DRB Application No.: 07DRB-70262 (P&F)
Project Name: UNIVERSITY HEIGHTS
Agent: WAYJOHN SURVEYING INC

DEVELOPMENT REVIEW BOARD – SPEED MEMO

RE: Lots 17 & 18, Block 23, University heights/p&f

**RE: Lots 17 & 18, Block 23, University Heights
Subdivision/sketch**

PLAT OF
LOTS 17-A, 17-B, 18-A & 18-B
BLOCK 23
UNIVERSITY HEIGHTS

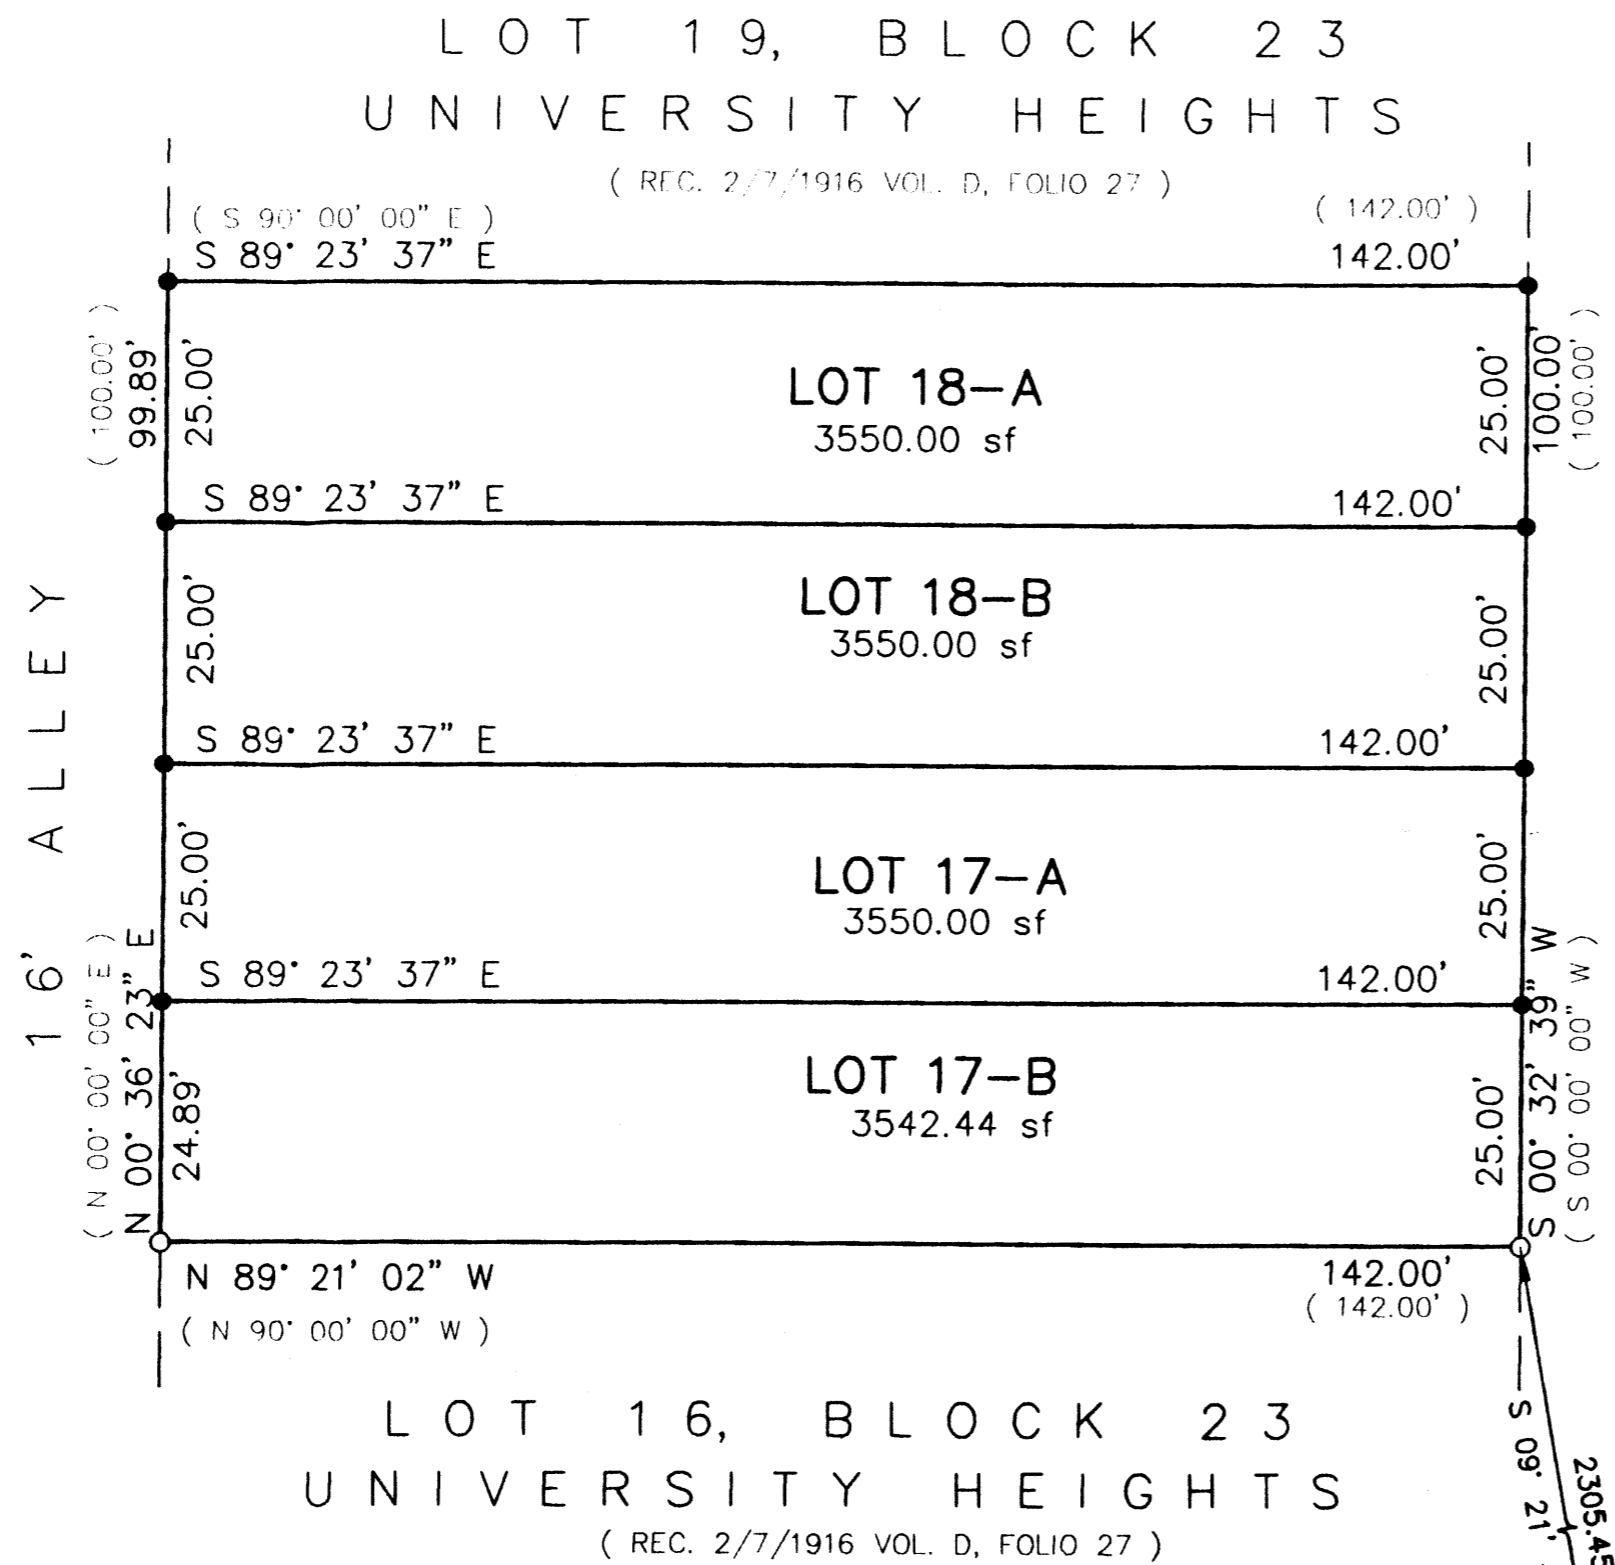
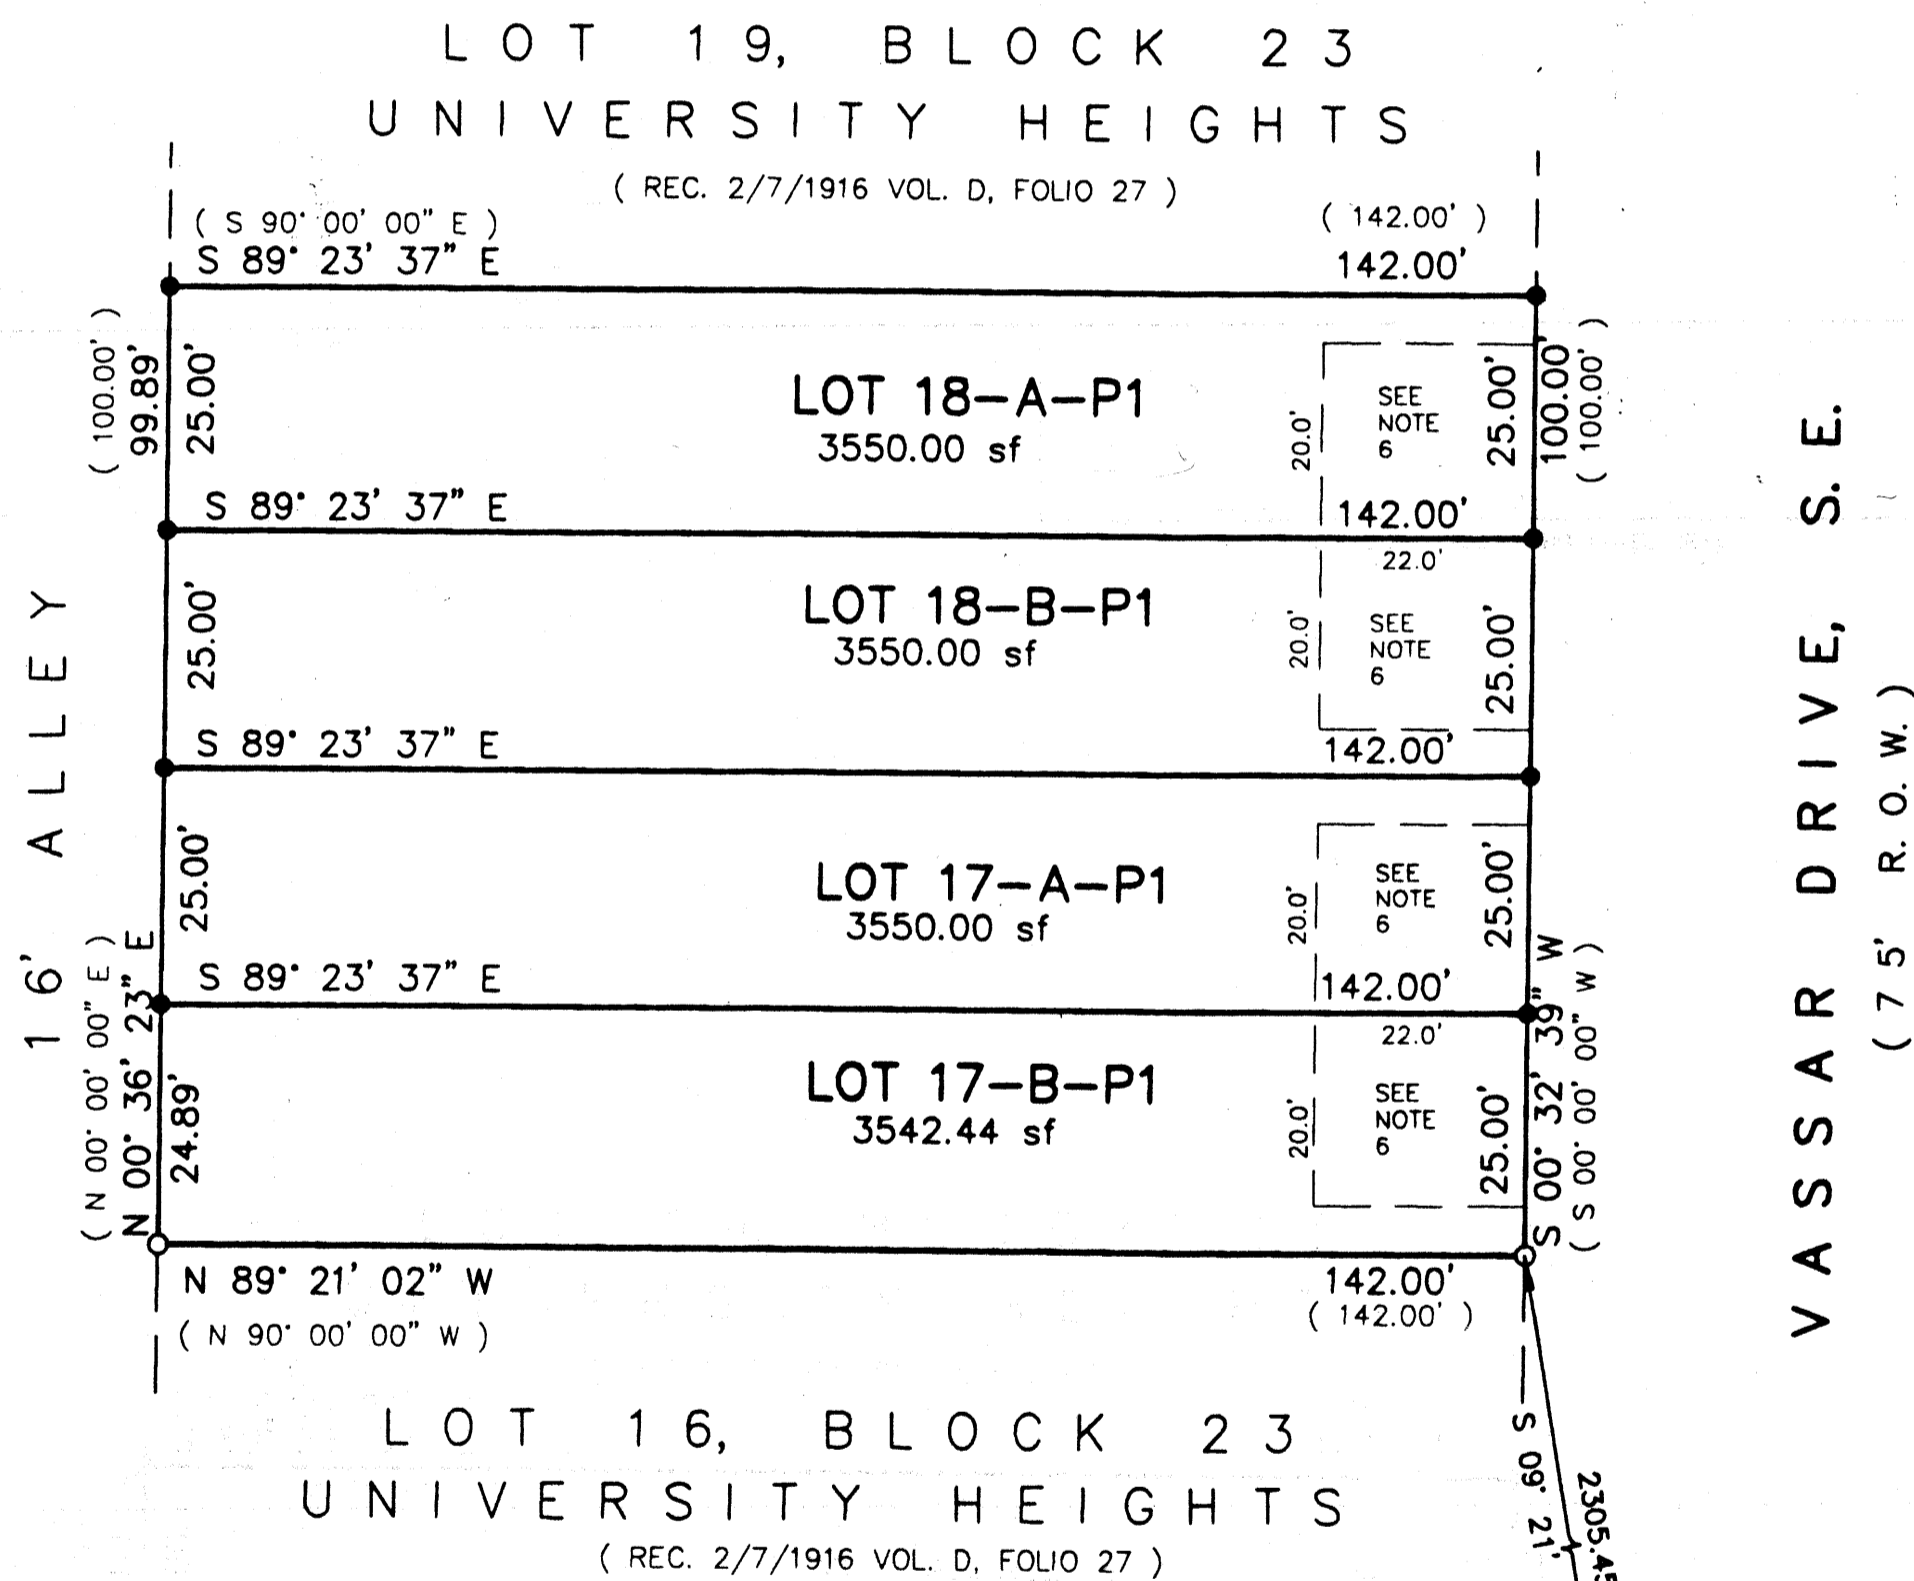
- 1) What is the change from one lot into two lots?
- 2) Assuming these will be P2 designated lots.
- 3) How will the drive pads work? Is there any parking on Vassar? (A 25' lot width does not allow on street parking)
- 4) What is distance from face of curb to the property line?
- 5) Will the alley be used for access? (20' alley?)
- 6) What is the sidewalk width?
